# KIRKLEES METROPOLITAN COUNCIL INVESTMENT & REGENERATION SERVICE

Reference No:	<b>2024/65/90270/W</b>
Site Address:	Queensgate Market, Princess Alexandra Walk, HD1 2UJ
Description:	Listed Building Consent for demolition, alteration, refurbishment and extension to create library, food hall and public realm (part within a Conservation Area)
Recommending Officer:	David Wordsworth

## **Application: 2024/90270**

**Proposal:** Listed Building Consent for demolition, alteration, refurbishment and extension to create library, food hall and public realm (part within a Conservation Area).

6.2.5 Second Floor Plan

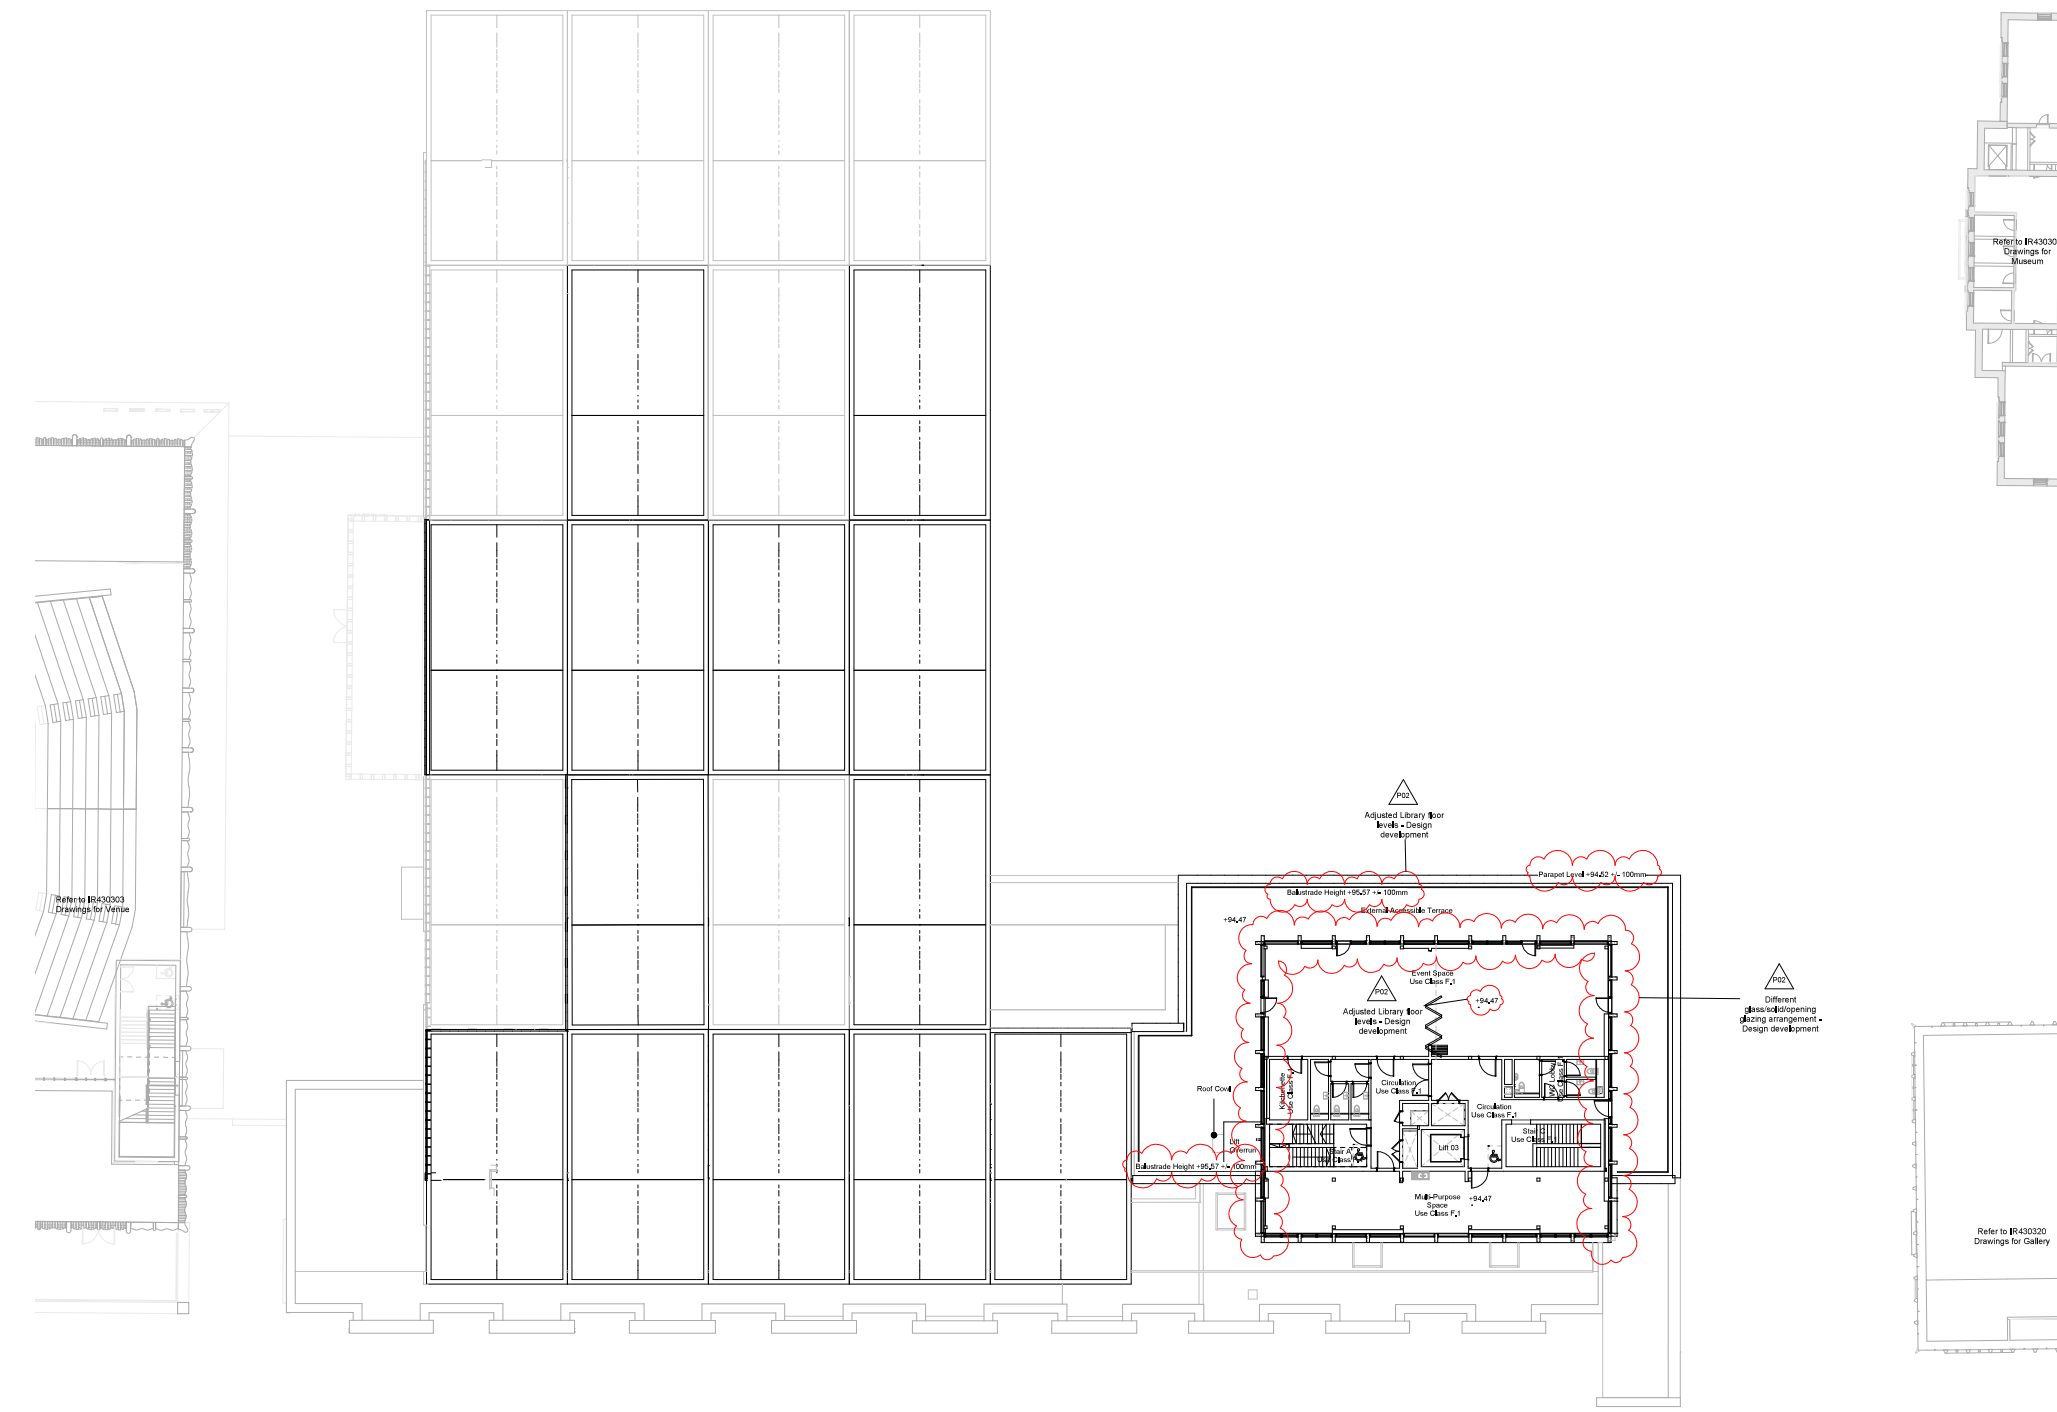
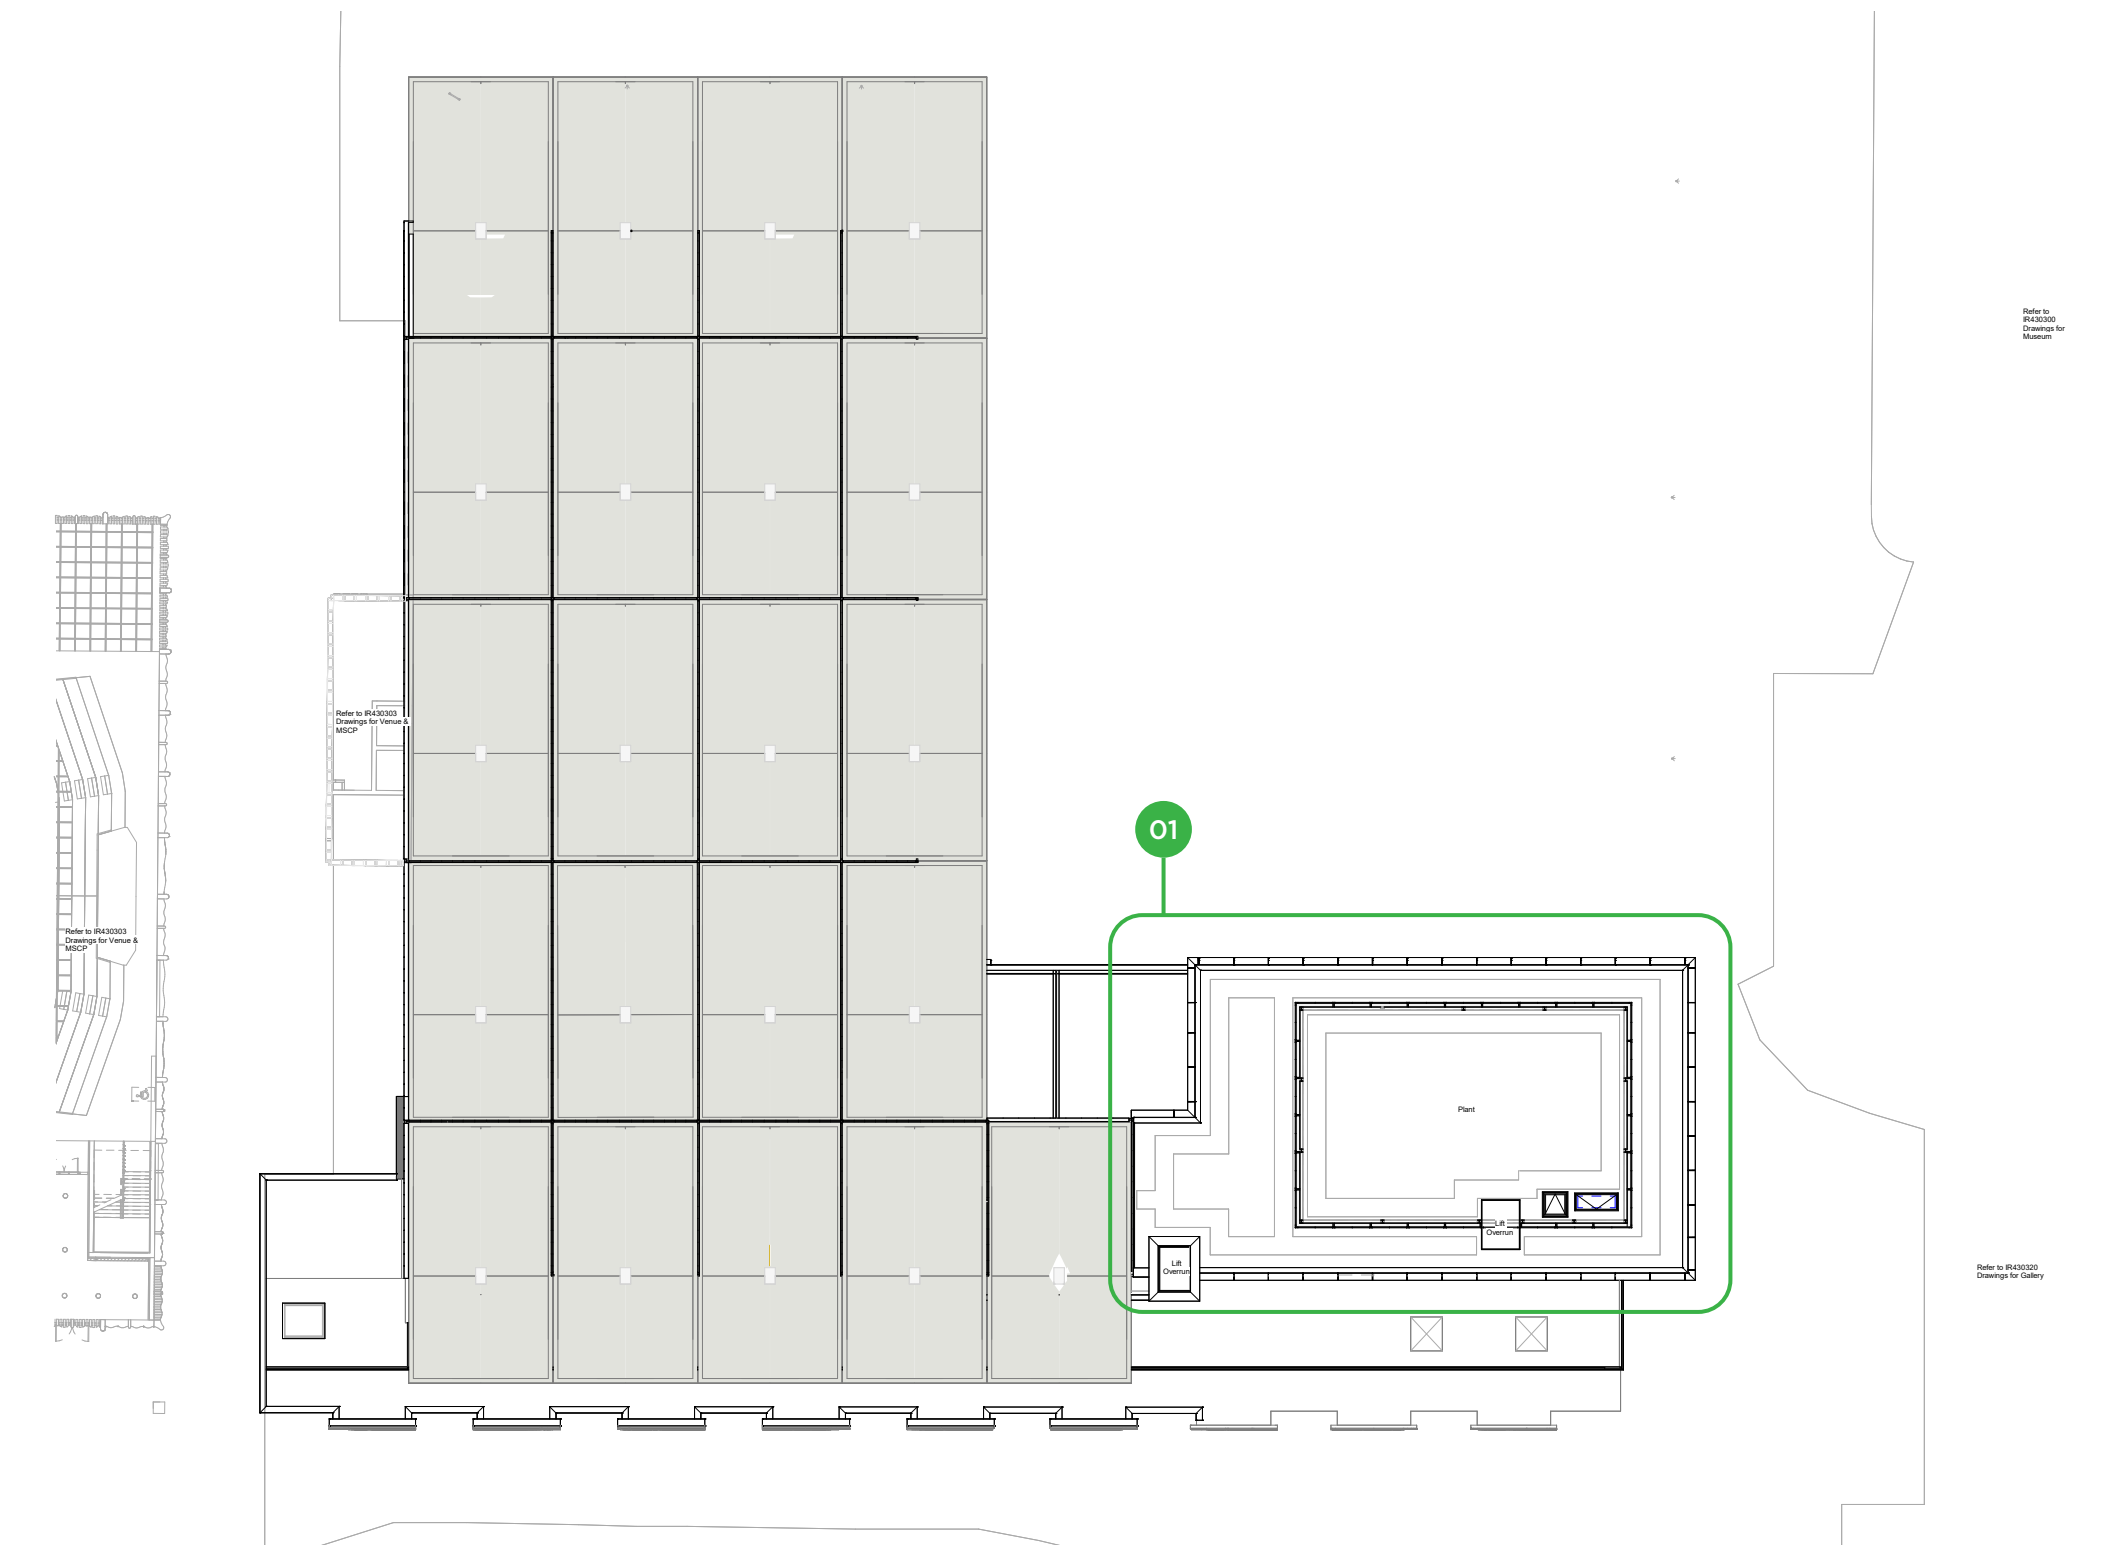
*Omission of Level 2 of the library extension:*

This extension is no longer required and would be an enhancement as it would reduce the external alterations to the original building, with views of the Grade II listed St Paul's Hall and Huddersfield Town Hall maintained from the Piazza.

6.3.3 South Elevation

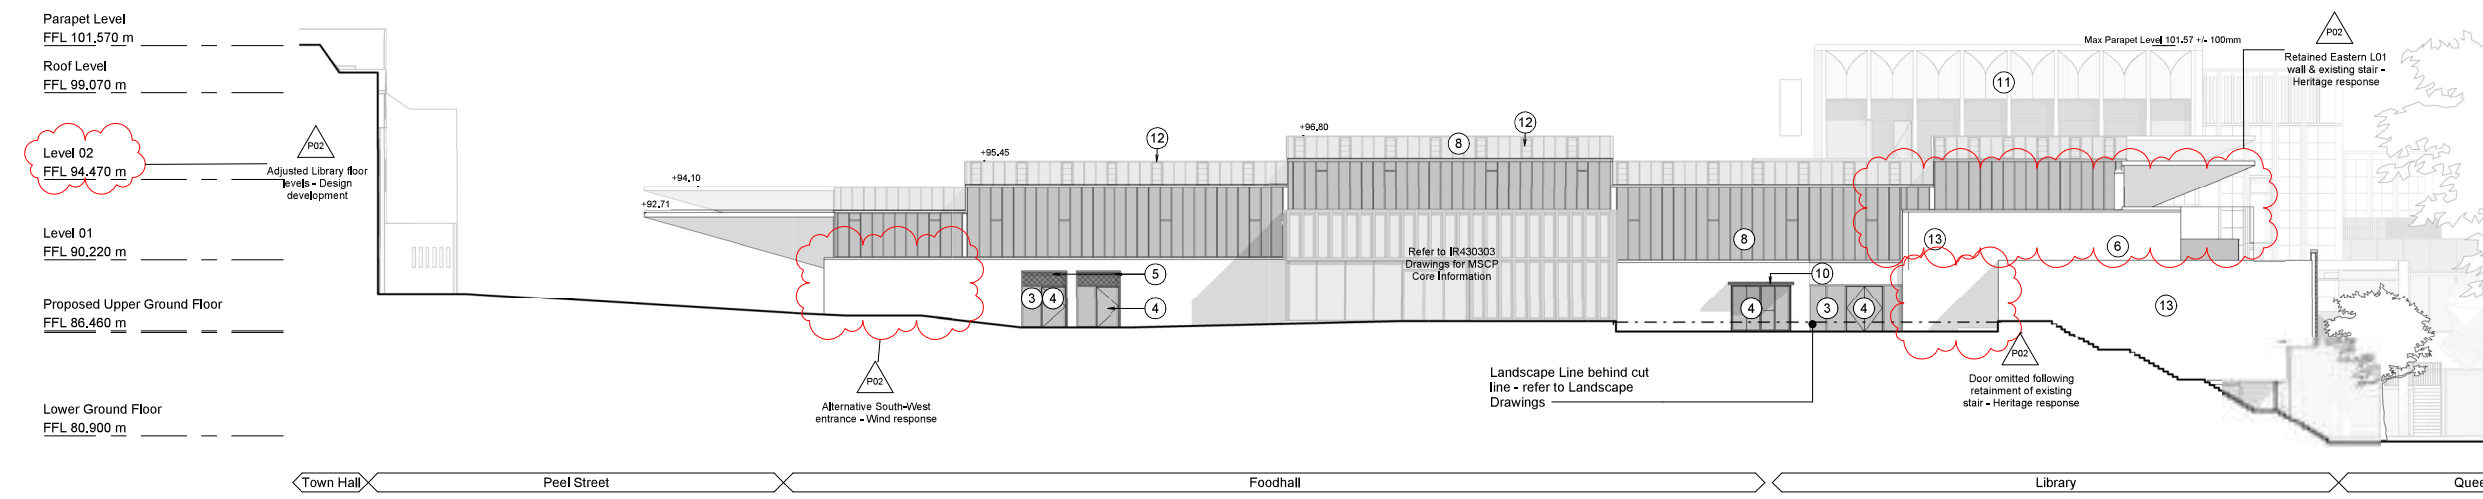
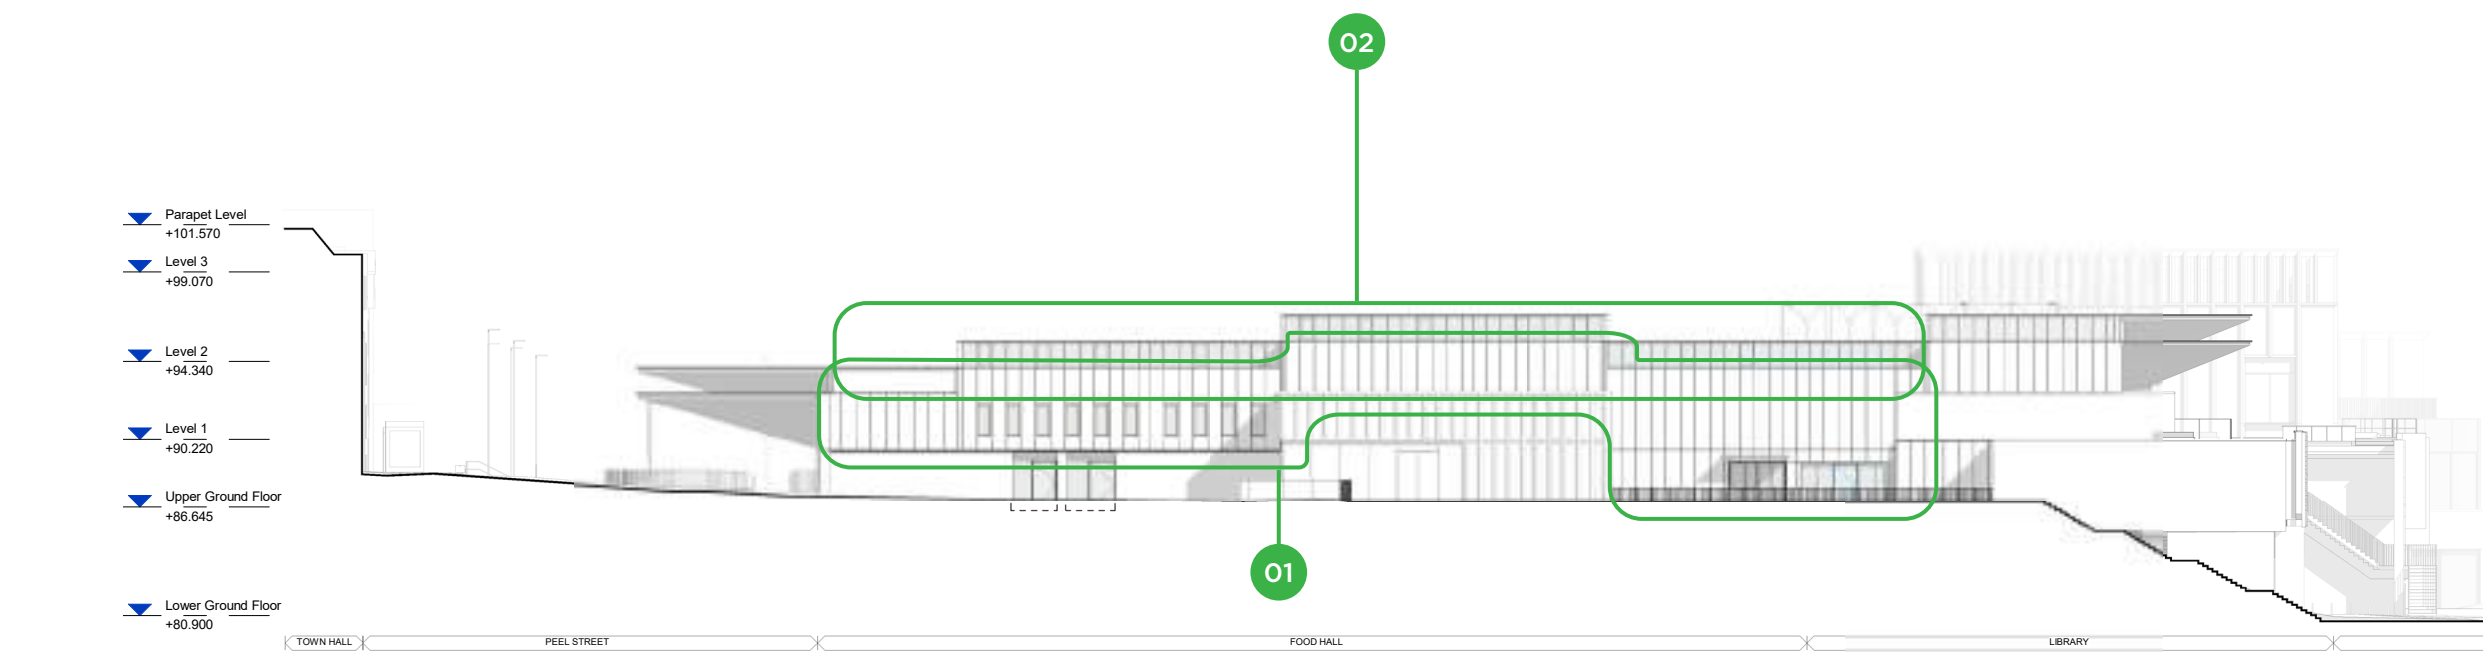
*Increase in the spacing of clerestory glazing:*

The replacement of all clerestory glazing has been approved. The frame sections of the proposed windows are thicker than the existing to take the weight of double-glazing. To ensure that the curtain walling has a lightweight appearance with a good proportion of glass to frame and to maintain the vertical proportions, these windows are slightly wider. New windows to the lower section on the west elevation are twice the width of those above, with the frames aligning with alternate mullions above. This is an acceptable design solution which maintains the vertical emphasis of the glazing and follows the configuration of clerestory glazing throughout the building, while also ensuring the structural integrity of the windows.
